From: Victor Grayson
Sent: 02 February 2026 08:36
To: DC Admin
Subject: Main Avenue, Cowlersley - 2024/93605

Potential Breach of policy LP11

Potential Flood risks

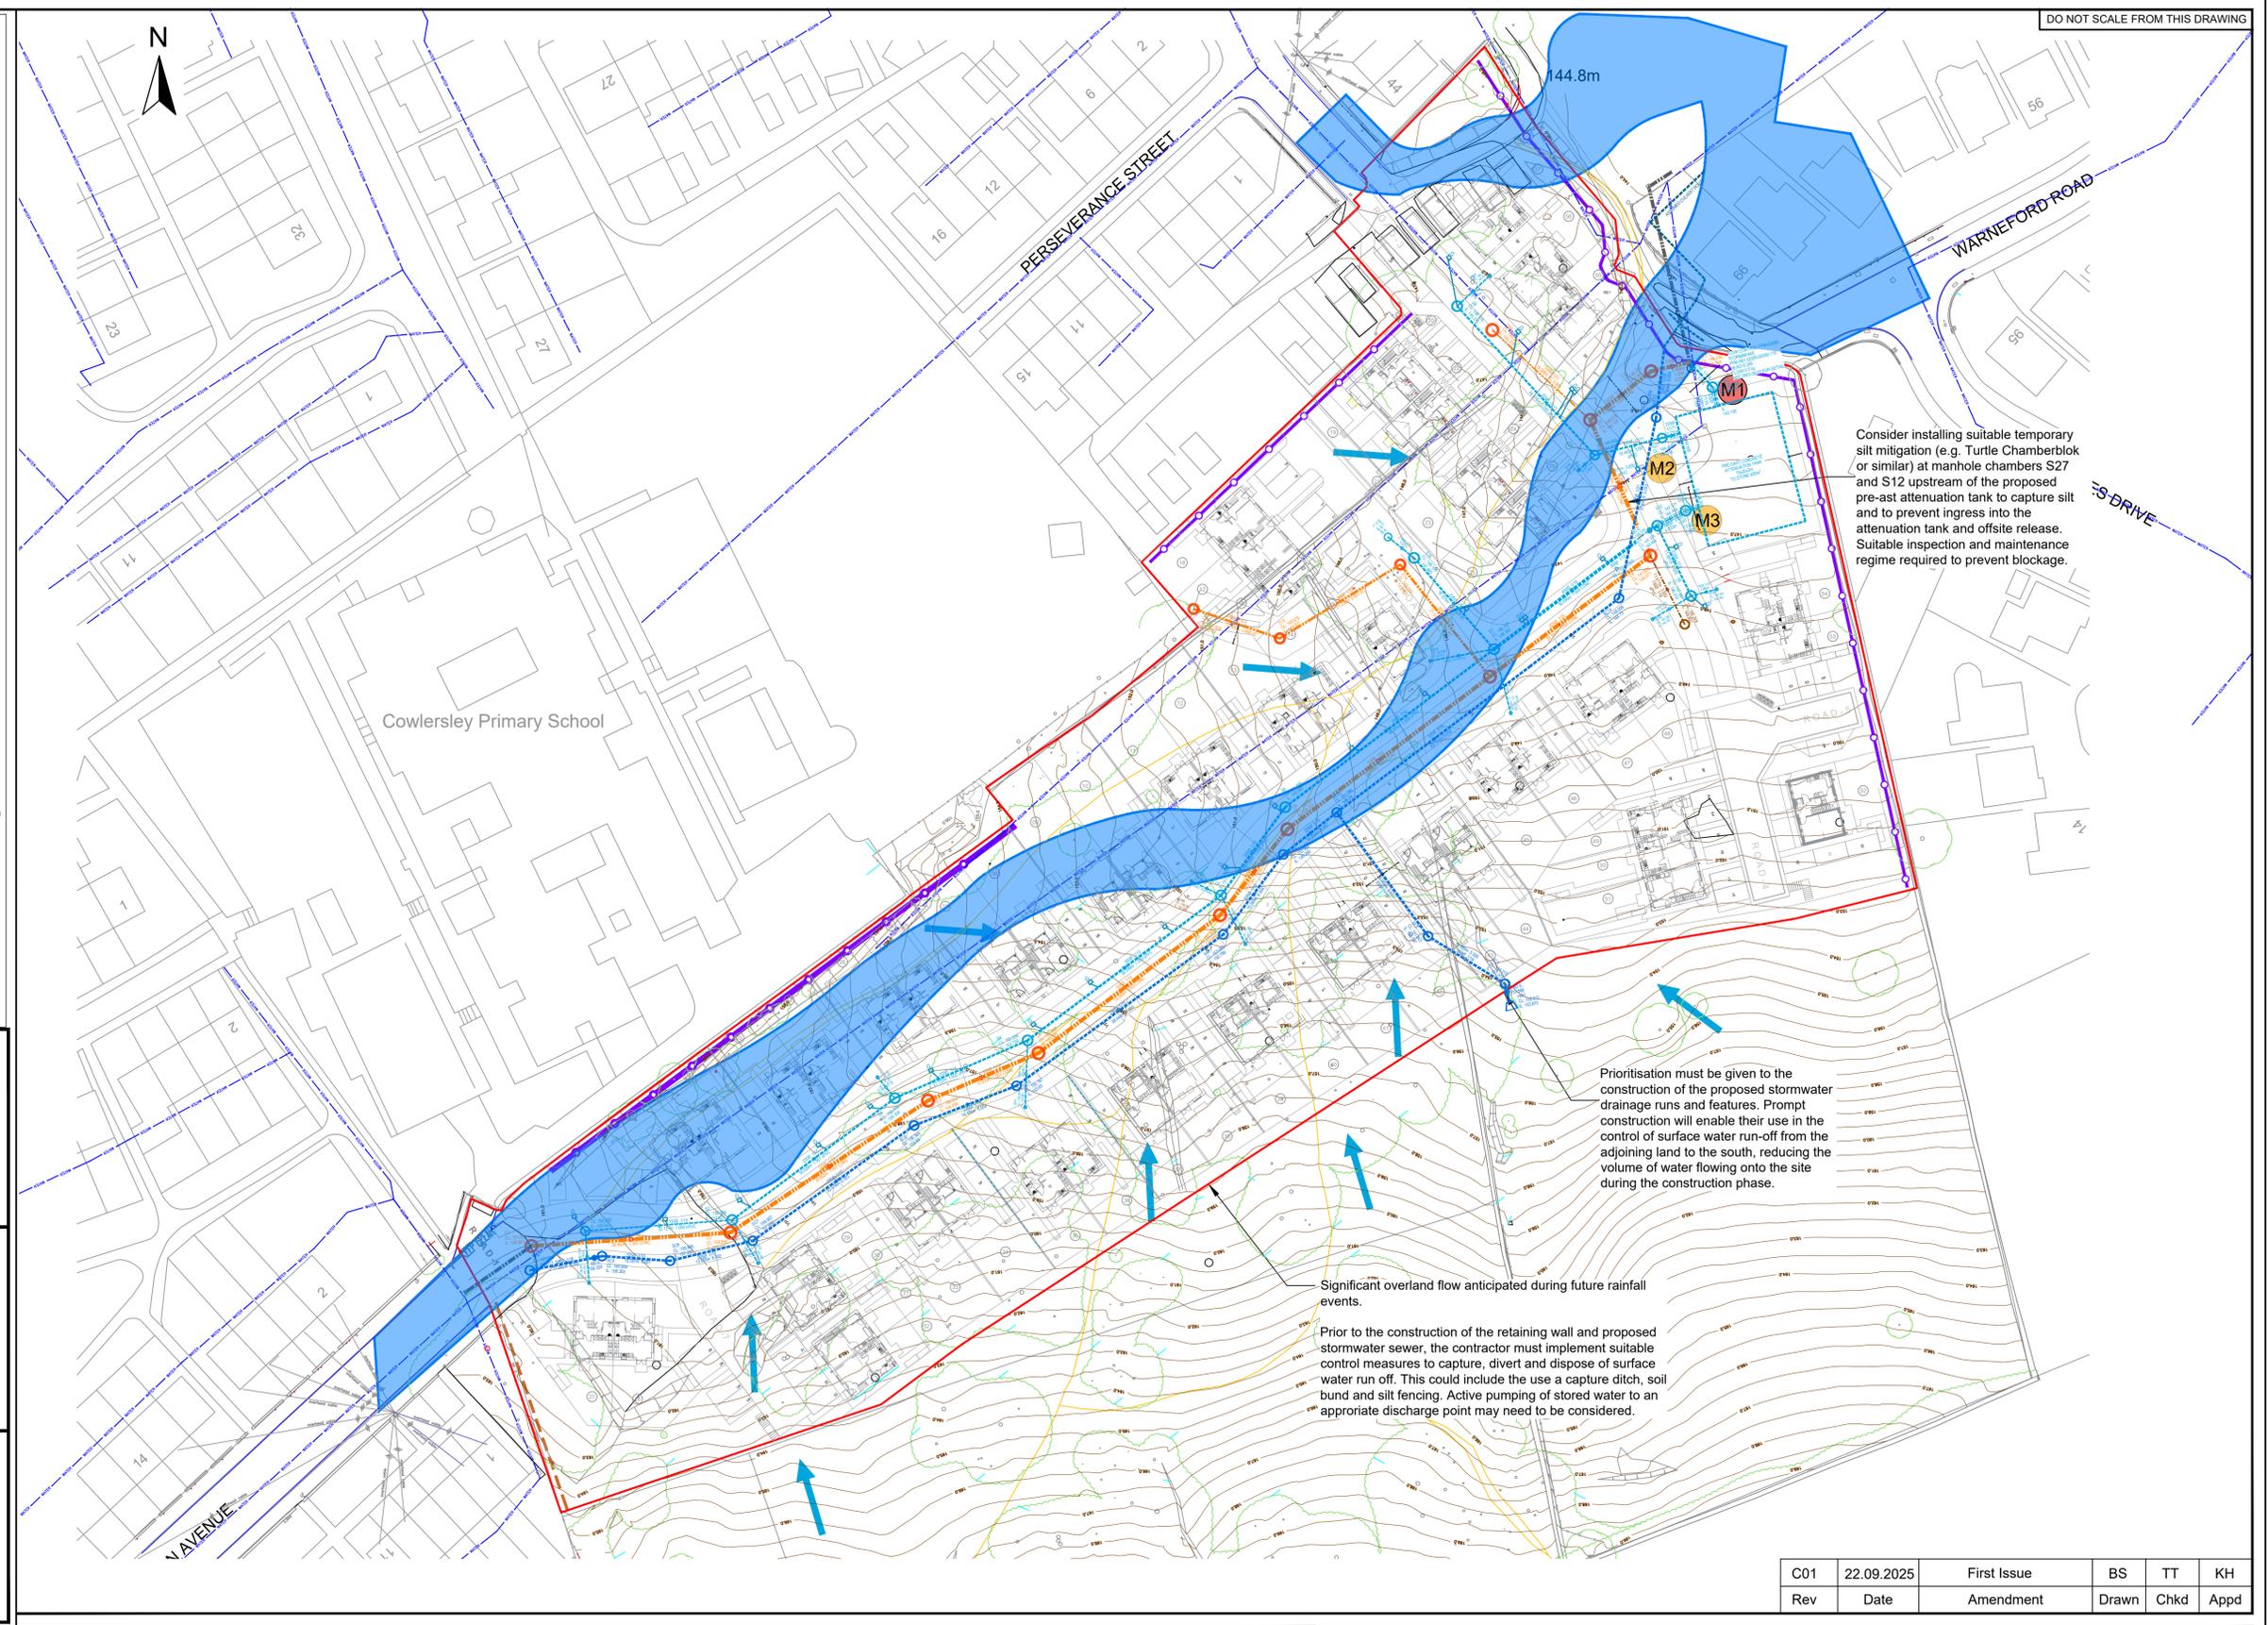
Construction surface water plan Section 4 page 5 states.

That water from the site will be diverted to an existing water culvert that runs through the gardens of homes in Warneford Road. Water will be directed to this culvert by the building of a retaining wall. It also comments on the need for anti silting mitigation measures being required, as it acknowledges that there will be a significant amount of runoff water in this area.
